DESCRIPTION OF REQUEST: Bosque Plaza Guardian Storage Site Plan for Building Permit for DRB final sign-off.

RE: Guardian Storage
Project #1004167

The purpose of this letter is to explain the modifications that have been made to the Site Development Plan for Building Permit. The project was approved by the Environmental Planning Commission (EPC) on May 12, 2017.

Site Development Plan for Building Permit EPC Conditions:

**GUARDIAN STORAGE**  
SITE PLAN FOR BUILDING PERMIT

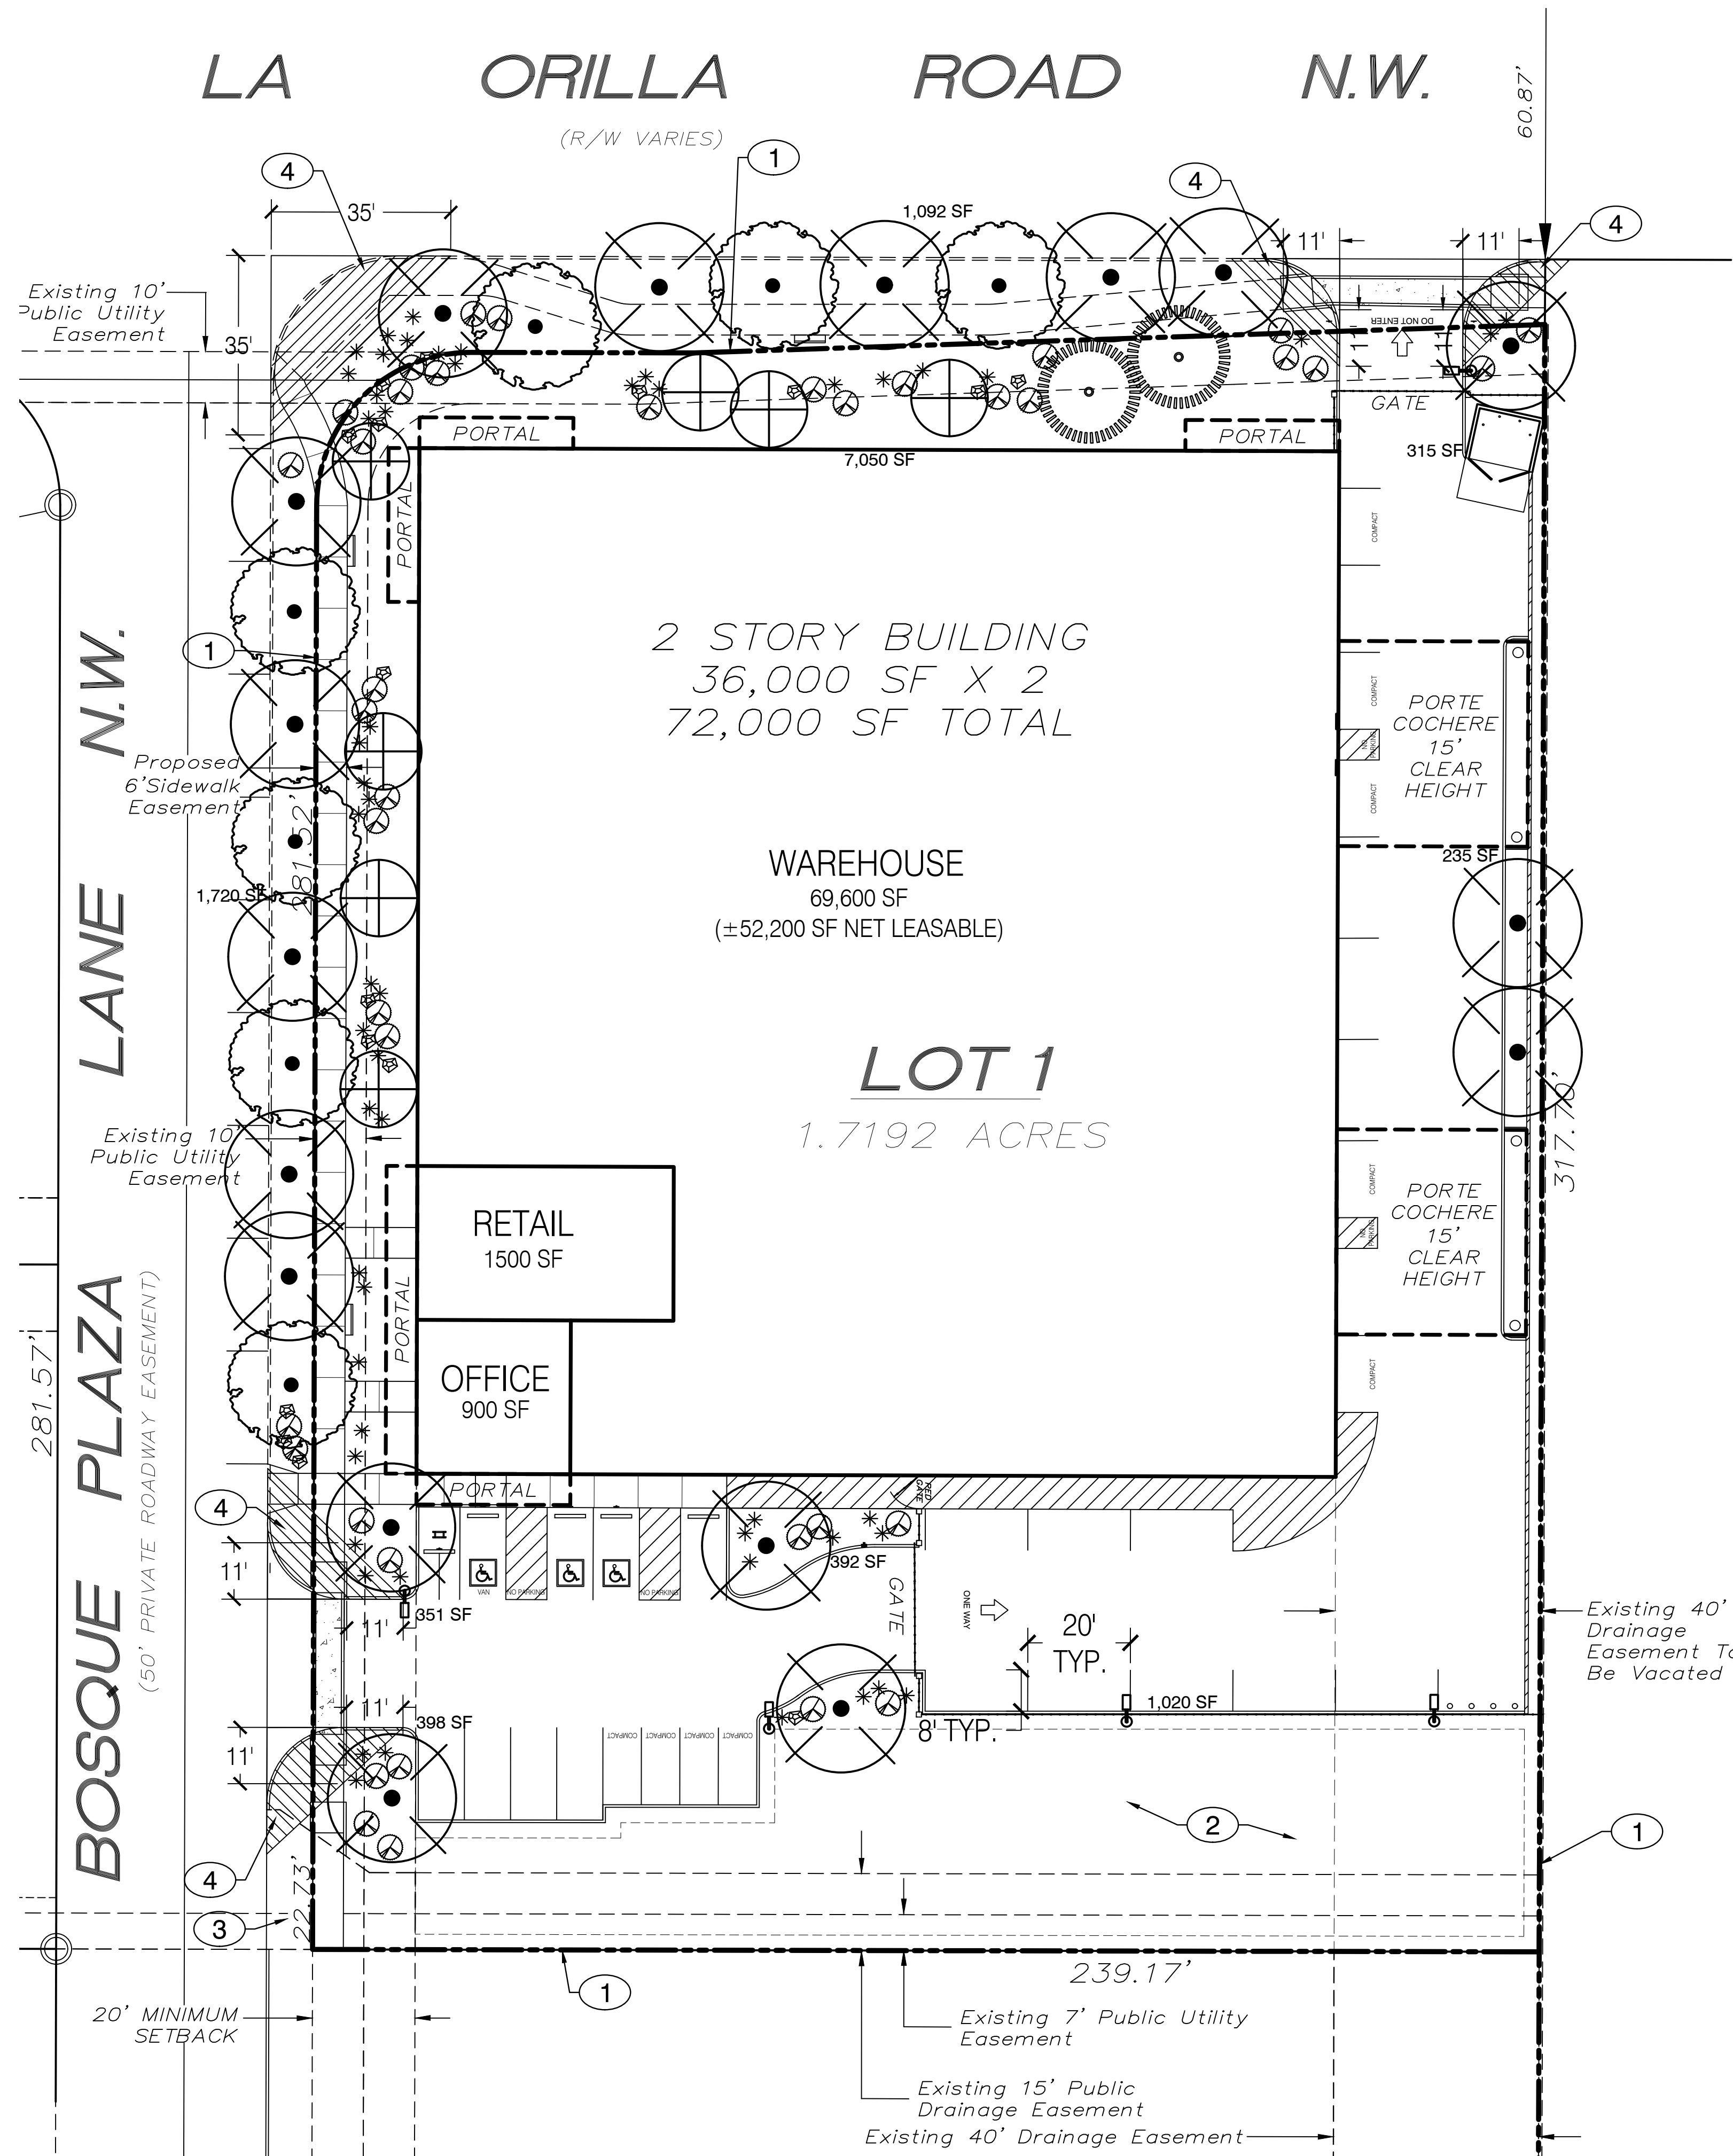
7. Window film signage shall be prohibited, and a note shall be added to the Site Development Plan for Building Permit regarding this prohibition.

General Note #8 was added to the Site Development Plan for Building Permit, sheet 1 of 7, stating "Window film signage shall be prohibited on all windows."

4. Applicant shall provide documentation for the use of parking along Bosque Plaza Lane, and shall submit an application to the City for use of the proposed on-street parking along La Orilla Road. Approval for the use of such spaces is necessary prior to final sign-off by the Development Review Board.

A letter from the Bosque Plaza Owner's Association has been provided with this application permitting on-street parking along Bosque Plaza Lane. An application for on-street parking credit, of 3 spaces, along La Orilla Road was submitted to the City and was denied due to interference with an existing right turn lane into the adjacent church parking lot. The site plan was modified to remove the proposed on-street parking along La Orilla Road and to reconfigure the on-site parking with an additional 3 spaces by utilizing compact parallel parking spaces along the back of building loading drive.

ELV-2

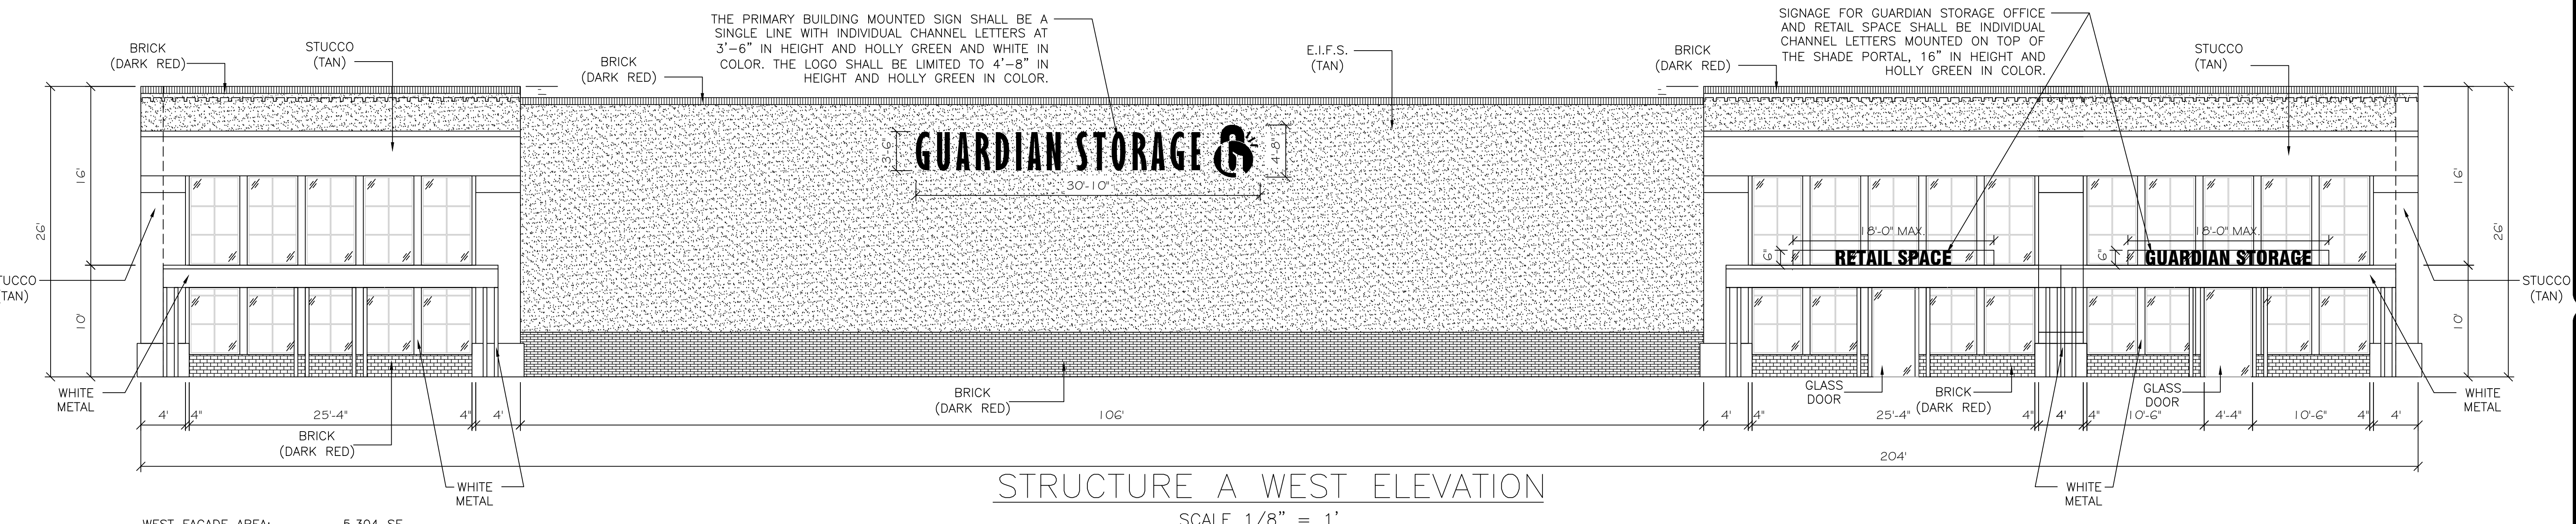
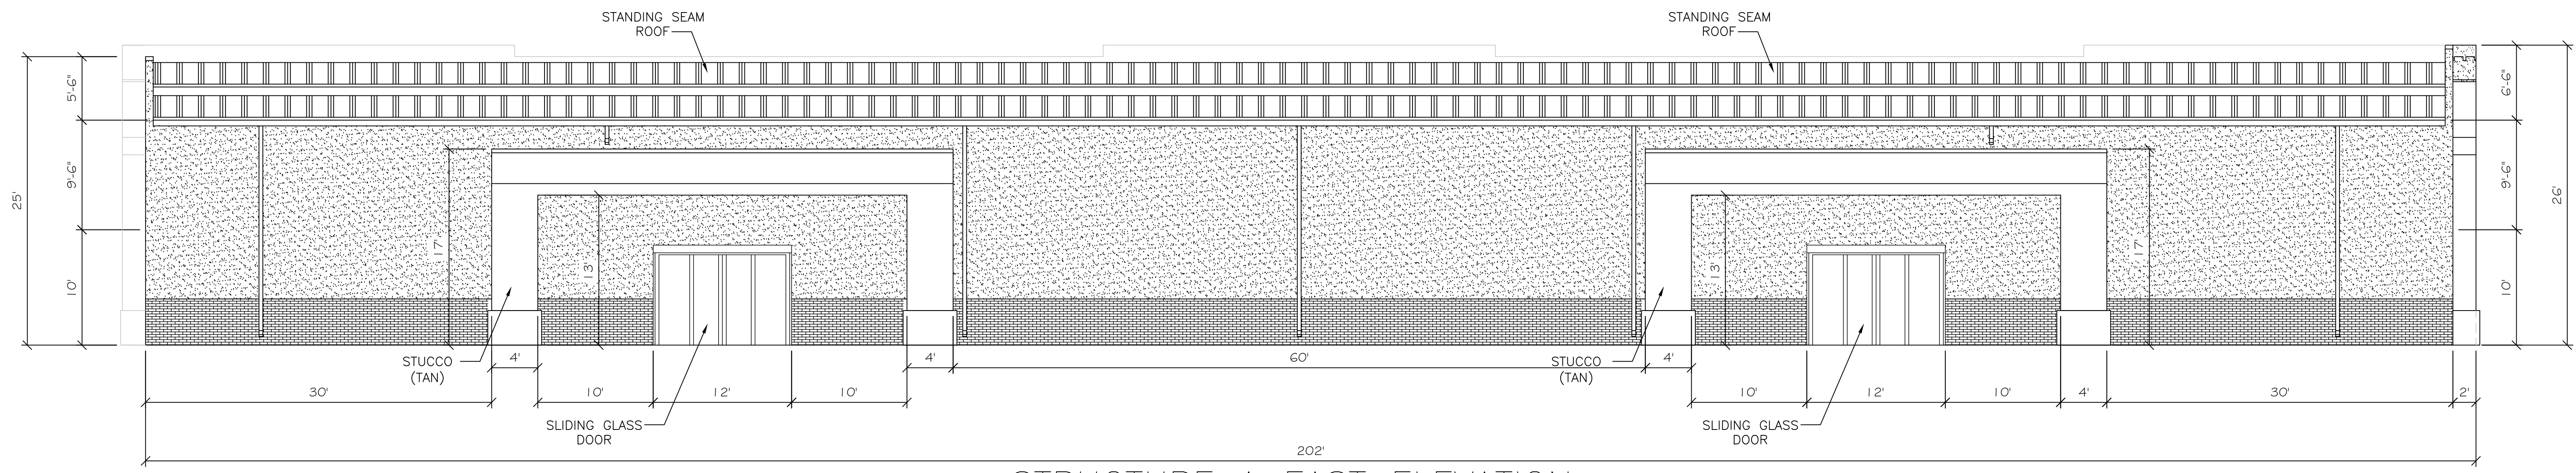
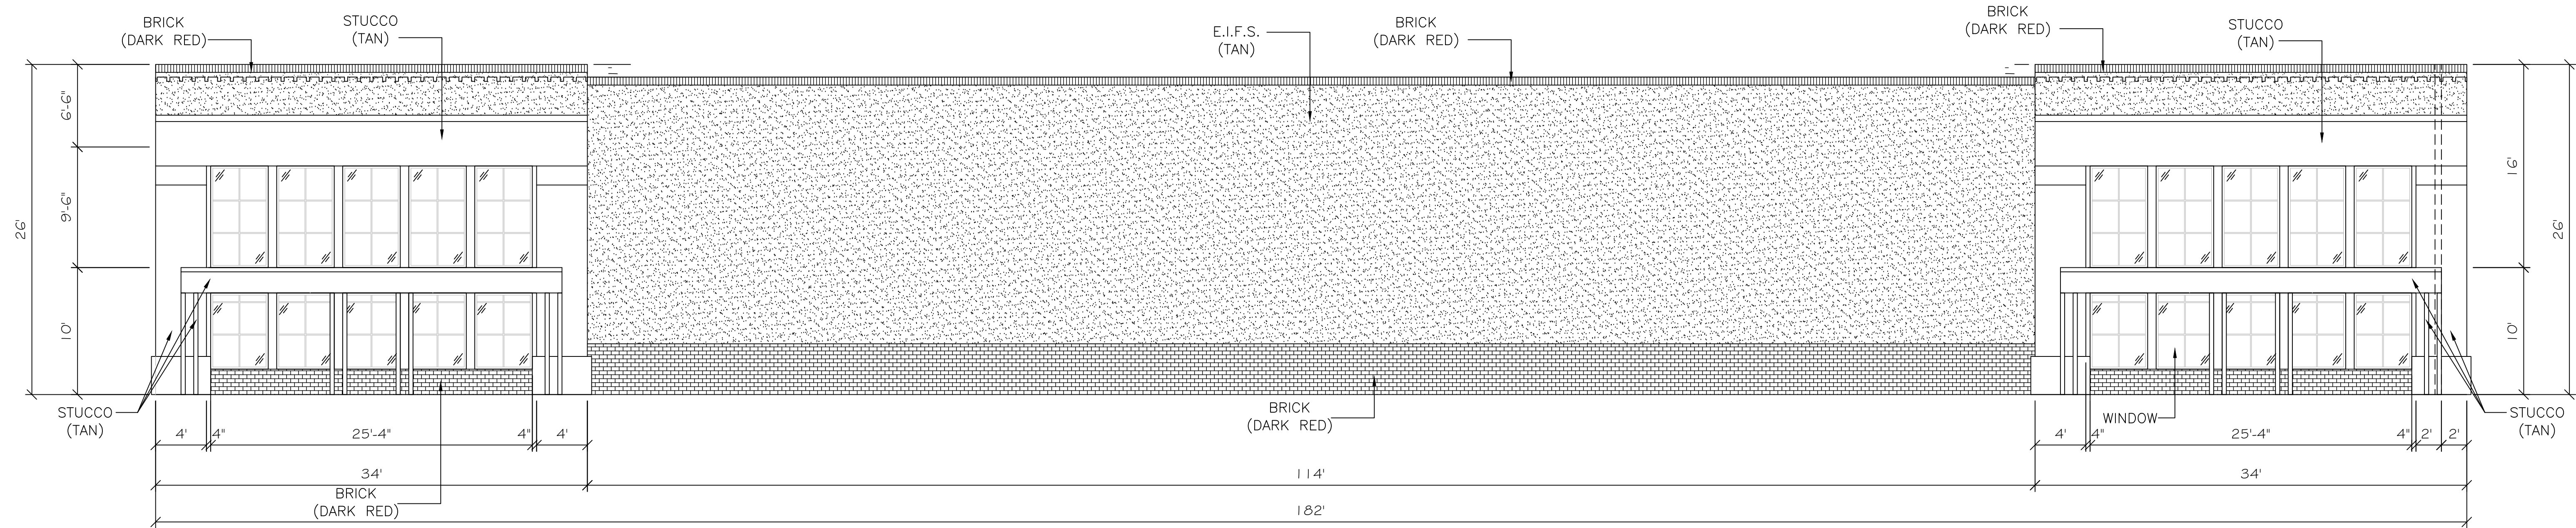
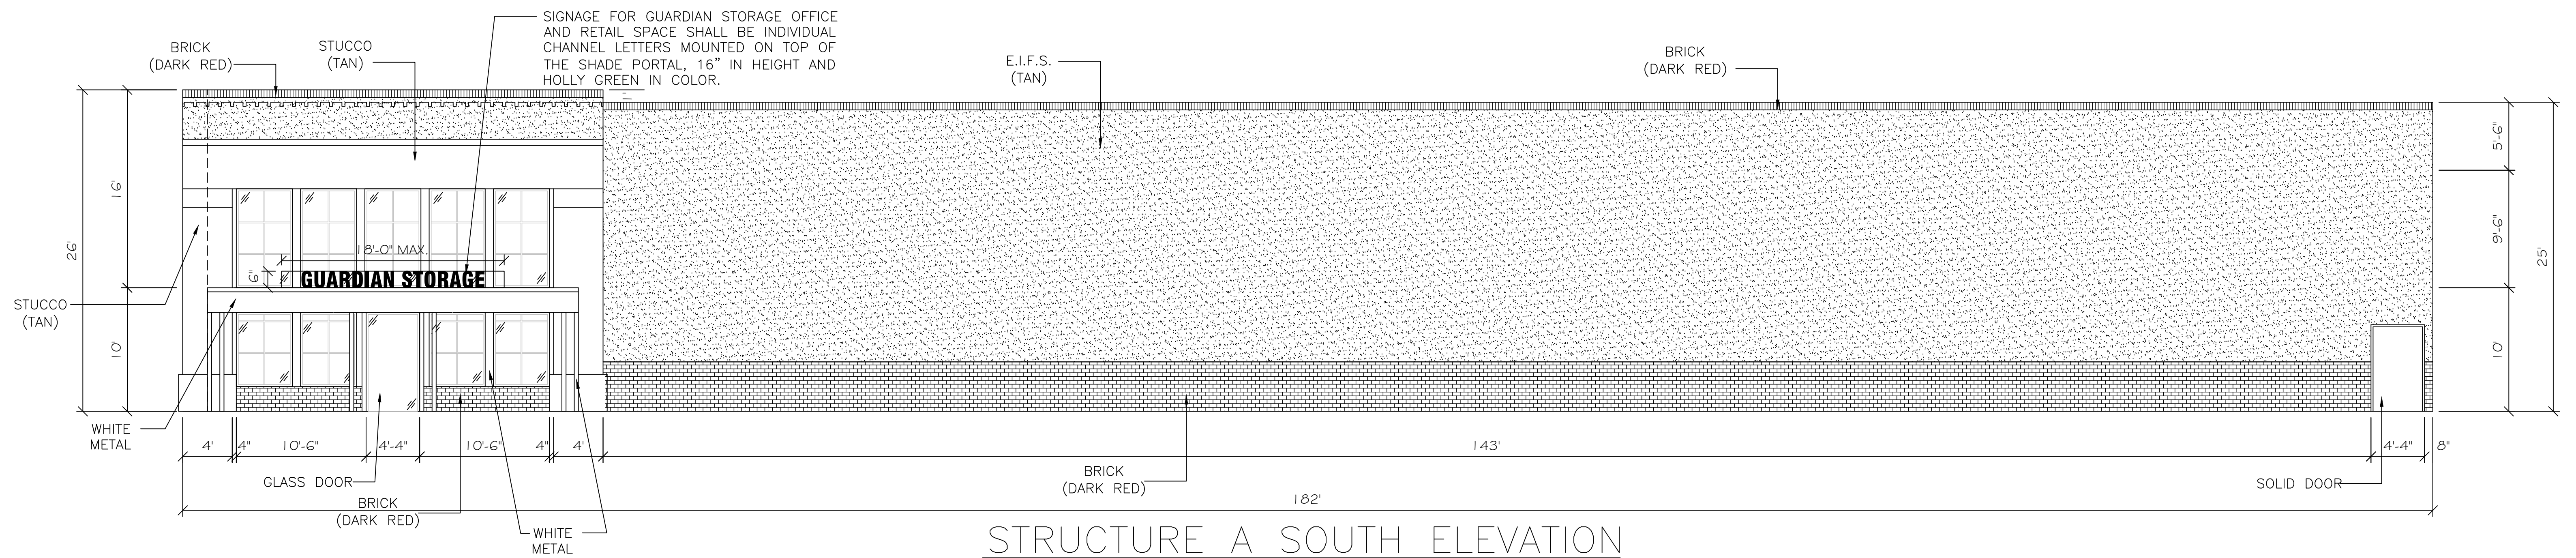
6. The building mounted signage on the west and south facades shall be revised to more closely resemble the rendering included in the recently approved amendment to the Site Development Plan for Subdivision. The signage for the Guardian Storage office and retail space shall be individual channel letters mounted on top of the shade portal, 16 inches in height, and Holly Green in color. The primary building mounted sign for Guardian Storage (west facade) shall be modified to be a single line with individual channel letters at 42 inches in height and Holly Green and White in color. The logo shall be limited to 4 feet 8 inches in height. All letters shall be internally illuminated LED modules. Total sign area must also comply with the requirements of the C-1 zone and the Site Plan for Subdivision.

The building mounted signage on the west and south facades has been revised to more closely follow the rendering included in the recently approved amendment to the Site Development Plan for Subdivision, see sheets 5 of 7 and 6 of 7. The total sign area complies with the requirements of the C-1 zone and the Site Development Plan for Subdivision.
